August 9, 2023

Subject: **Geotechnical Assessment for Site Stabilization**
5236 West Mercer Way
Mercer Island, Washington

Reference: *Geotechnical Engineering Site Assessment, Site Construction Suspended, 5236 West Mercer Way, Mercer Island, Washington; WSP; June 8, 2023.*

5236 W MERCER WAY
SINGLE FAMILY RESIDENCE
TESC AND CONSTRUCTION
MANAGEMENT PLAN

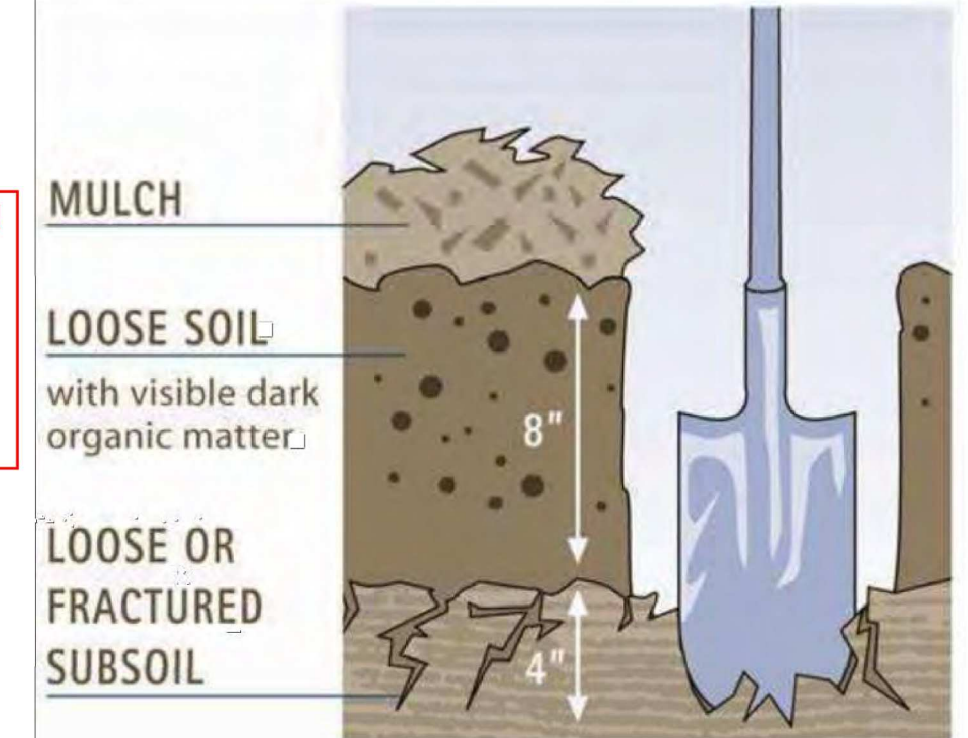
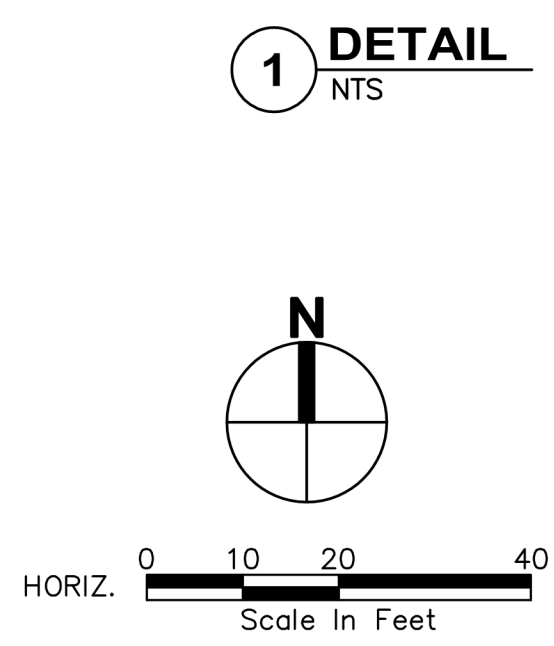
1. Gabion basket walls were supposed to be constructed before the soldier pile walls, but were not. Instead, there is a 2H:1V cut slope of bare soil behind the east wall. The cut slope should be protected with a staked biodegradable erosion control mat and hydroseeding according to WSDOT Standard Plan I-60.10-01.

2.The shoring walls seems to be well constructed and according to plan; however, there are some voids behind the lagging in some locations. The wall should be backfilled with free-draining material (such as pea gravel) to within 1 to 2 feet of the top of the wall. One foot of freeboard should be maintained for catchment of any erosion from the slope above the wall.

3.The basement excavation appears to be near the design elevation. A drainage swale should be constructed along the base of the walls to collect any seepage through the wall. The swale could direct water to the two sediment traps at northwest and southwest ends of the walls (see Photos).

4.The perimeter silt fencing needs to be replaced, improved, and/or maintained to meet the standard details for high visibility silt fence, as shown on C1.1 TESC Details and WSDOT Standard Plan I-30.16-00.

5.Add silt fencing between the north side of the paved driveway and the cut slope to prevent sediment transport on the paved driveway.

7.Install the interceptor swale with check dams along the south side of the driveway as shown on the TESC Plan.

8.Construct a check dam or two on the driveway that slows and diverts surface runoff to the interceptor swale.

9.Regrade the area at the top of the driveway (house footprint) to control surface runoff. Regrade the two small ponds (see photos) for safety (not too deep or steep) and to function as sediment traps. Regrade stockpiles as needed to smooth slopes.

10.Hydroseed the bare ground surface, including cut slopes, and cover stockpiles with tarps.

Response: Covering the cut slope with a coir erosion control mat is appropriate. If such a material is staked directly against the soil, then hydroseeding should not be necessary. Due to irregularities in the face of the existing slope, it may be necessary to accomplish limited removal of the "humps" of disturbed soil to create a smoother, more uniform surface on which to lay and stake the erosion control mat.

Response: We concur with this recommendation. The small amounts of leaves and debris that have accumulated on top of the pea gravel that has been placed thus far must first be removed before completing the backfilling of the lagging.

Response: A drainage collection swale along the face of the eastern soldier piles is appropriate. Based on the project plans, it appears that the excavation along the soldier piles was accomplished to the elevation of the perimeter foundation. Excavation below this level to create must be avoided. As a result, any swale will have to be created by building a small berm of soil across the face of the soldier piles, instead of excavating. This small swale would probably best be created with sand bags and then be lined with plastic.

Response: Unfortunately, in this application a silt fence would not be the most practical solution, as a silt fence is not effective at filtering silt out of runoff or protecting bare soil from erosion. We recommend instead that the existing short cut the north side of the driveway be cleaned and shaped to properly carry runoff, and then the soil be covered with a coir erosion control mat. This will protect the exposed soil from erosion.

Response: Establishing a swale along the low side of the driveway is appropriate.

Response: This is appropriate.

Response: This is appropriate.

Response: Depending on the time of year when the stabilization work is completed, hydroseed may not germinate and grow sufficiently to effectively cover areas of bare soil remaining outside of

the excavation. If this is the case, the bare areas could be covered with mulch and a coir erosion control mat.
